**Re:** Planning Application 18/0296

**Address: LAND REAR OF ROCKLEA AND STANDRIDGE WHALLEY ROAD  
BB7 9NA**

**Description: ERECTION OF THREE DETACHED, THREE-BEDROOM  
BUNGALOWS INCLUDING ACCESS.**

PROPOSED SITE PLAN

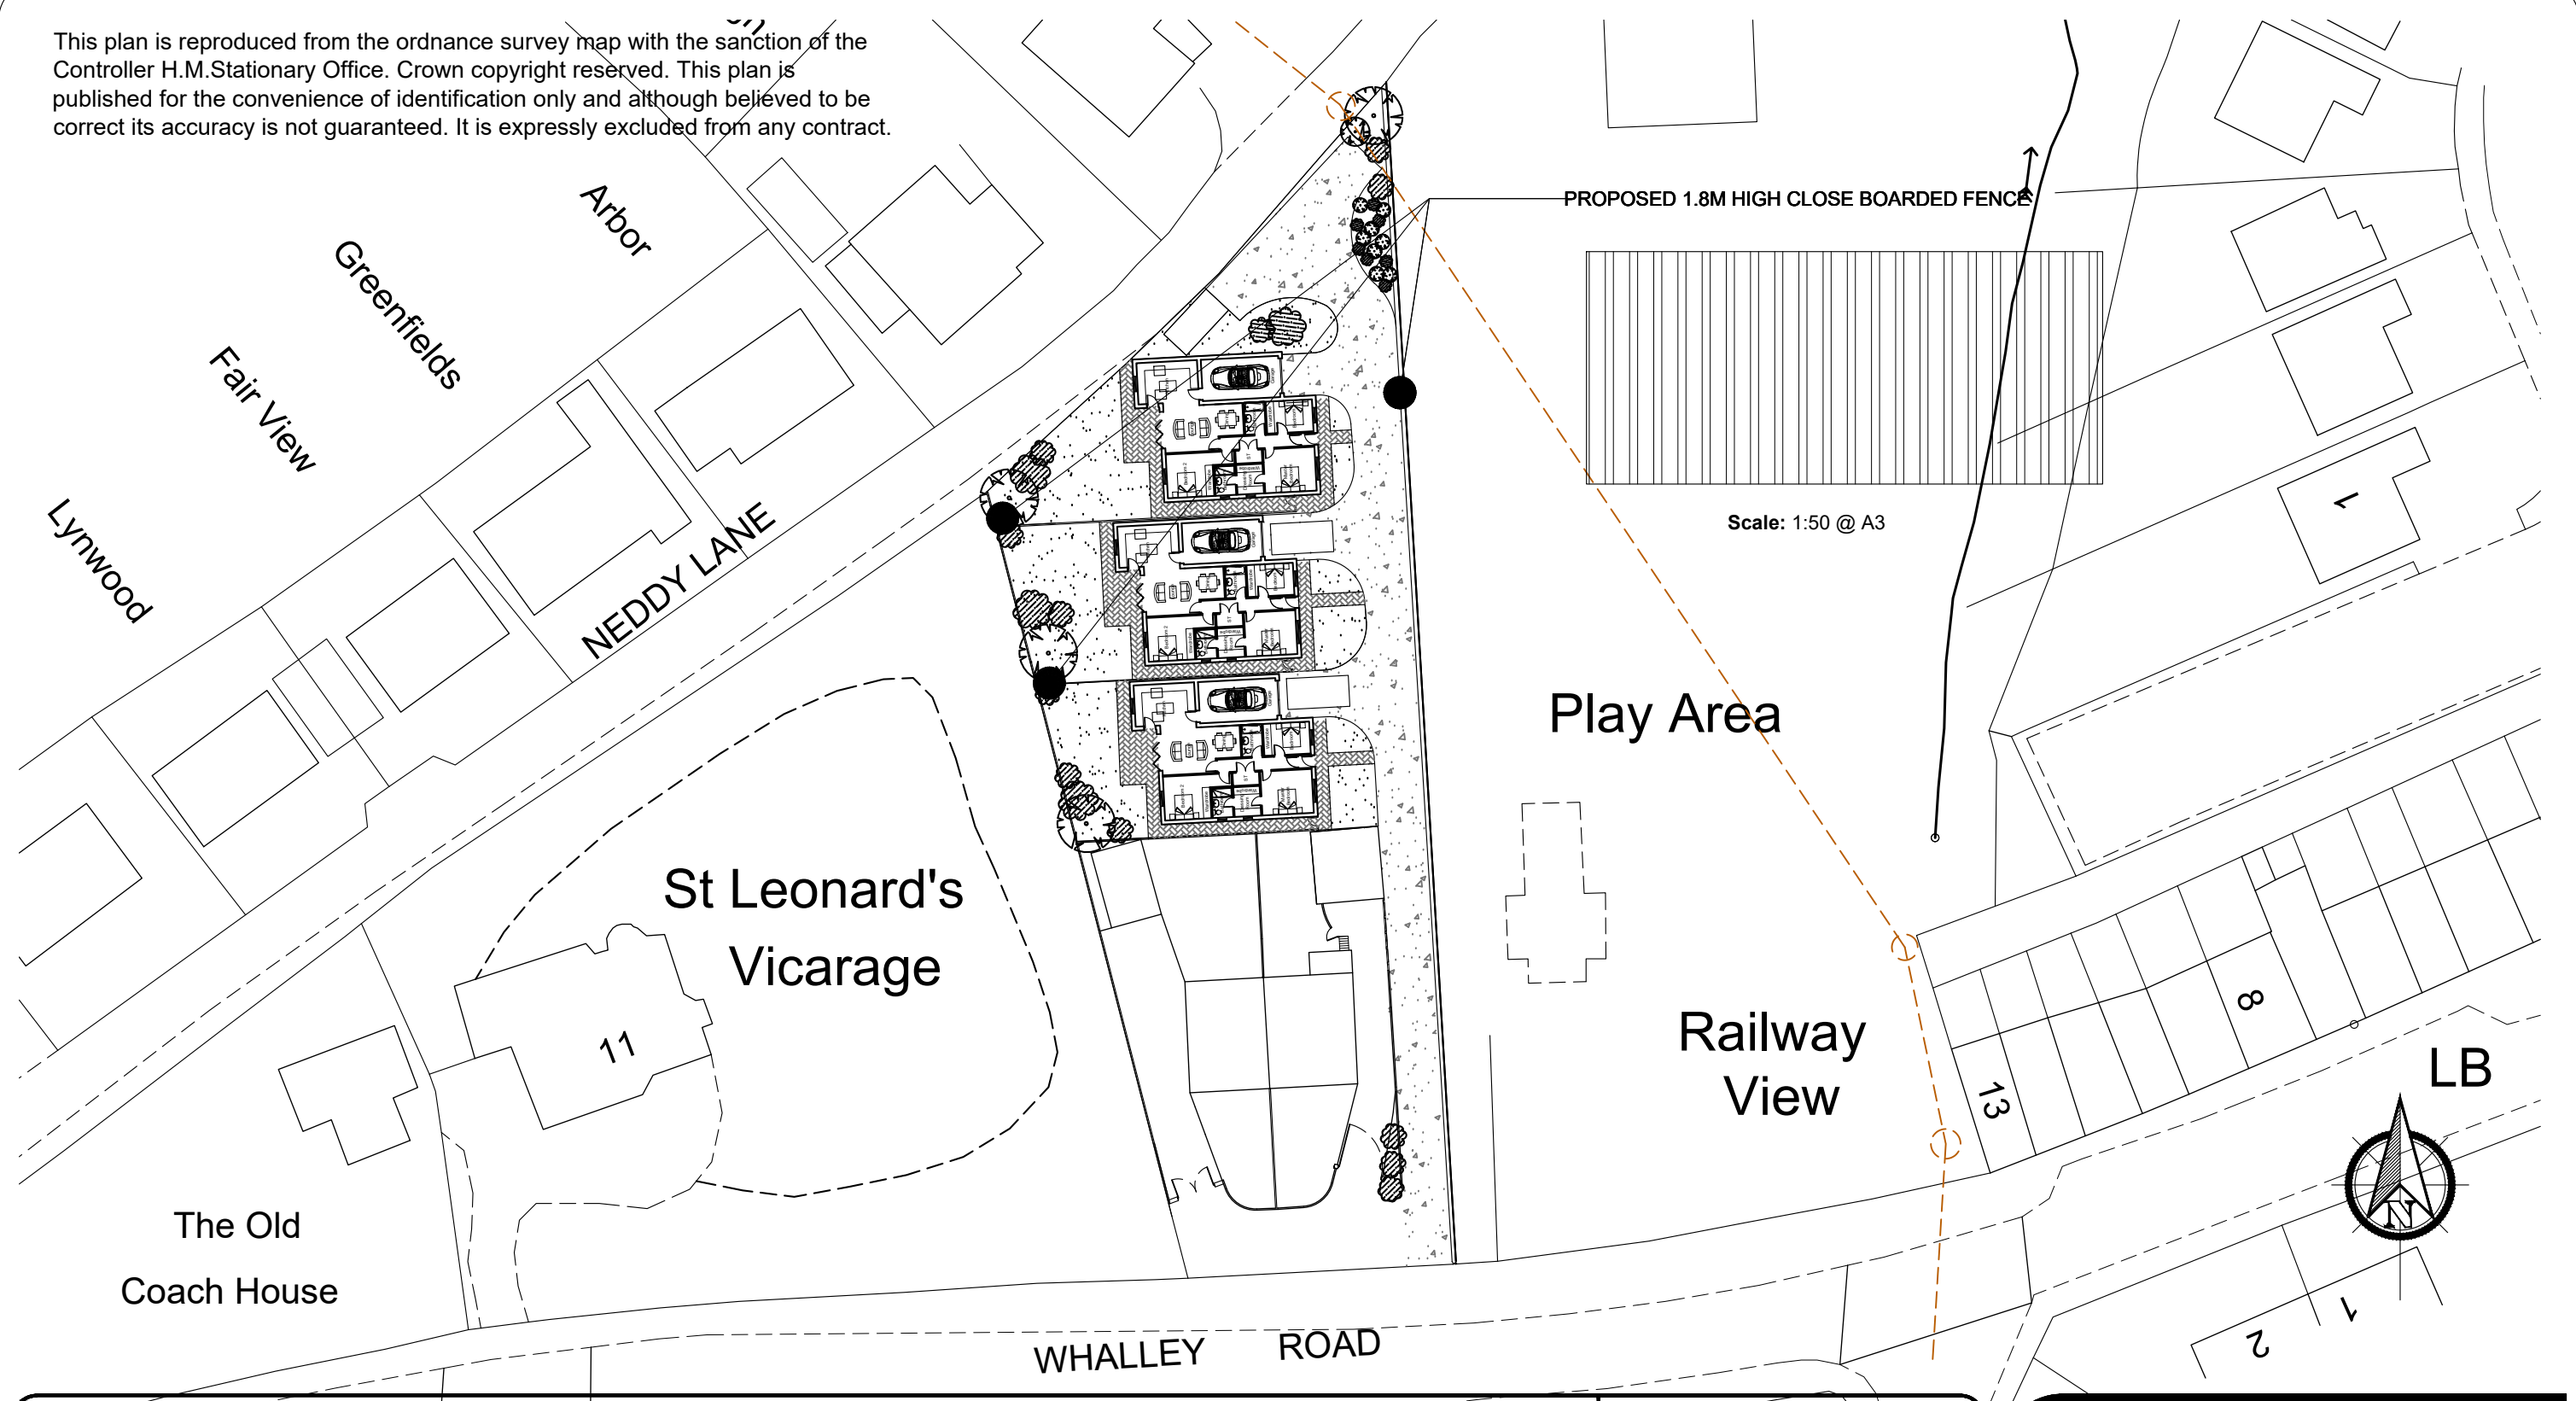
Using Lancashire's Residential Road Design Guide an access drive serving up to 5 dwellings would be expected to have a minimum width of 4.5m, this could include the service strip. The proposed drive measures 3.5m at its narrowest point with no space available for a service strip, should future works be required to the services for the properties, then if the access track was dug up the properties would effectively be cut off by car for the duration of he works.

There would appear to be no provision made for any waste bin storage or a collection point. The collection point should be sufficiently large enough to accommodate at 6 wheeled bins depending upon the collection cycle, the collection point should not impede the access to either the proposed development or the existing dwellings. The Department for Transport's Manual for Streets document would suggest that residents would not be expected to carry waste more than 30m to the collection point and that the collection vehicle should be able to get within 25m of the point.

There are concerns regarding the manoeuvring of vehicles from the driveways Manual for Streets would suggest that a free space of 6m would be expected from the edge of the drive to an obstruction, in order not to hinder movements in or out of the driveway. This has not been achieved at 2 of the 3 dwellings. The parking

provision for the 3<sup>rd</sup> plot, with the remote car parking space, may not be sufficiently wide enough to allow for the car doors to be opened without fouling against an obstruction such as a fence or hedge it would be expected that an additional 0.6m in width should be provided.

Whilst a turning head has been provided it would appear to be quite tight, a swept path analysis should be provided for a delivery vehicle such as a large delivery van (7.0m x 2.6m) to ensure that it is practical and suitable for purpose. Similarly it is uncertain if a vehicle such as a Fire Engine could be accommodated on the paved area, they would expect 3.7m between the kerbs and sufficient space to walk around the vehicle, whilst attending an incident they are not expected to reverse more than 20m.

The proposed fence to the east of the site will need to be foreshortened by 5m so that other road user either entering the site or pedestrians leaving the adjacent play area can see if a vehicle is about to emerge from the development.
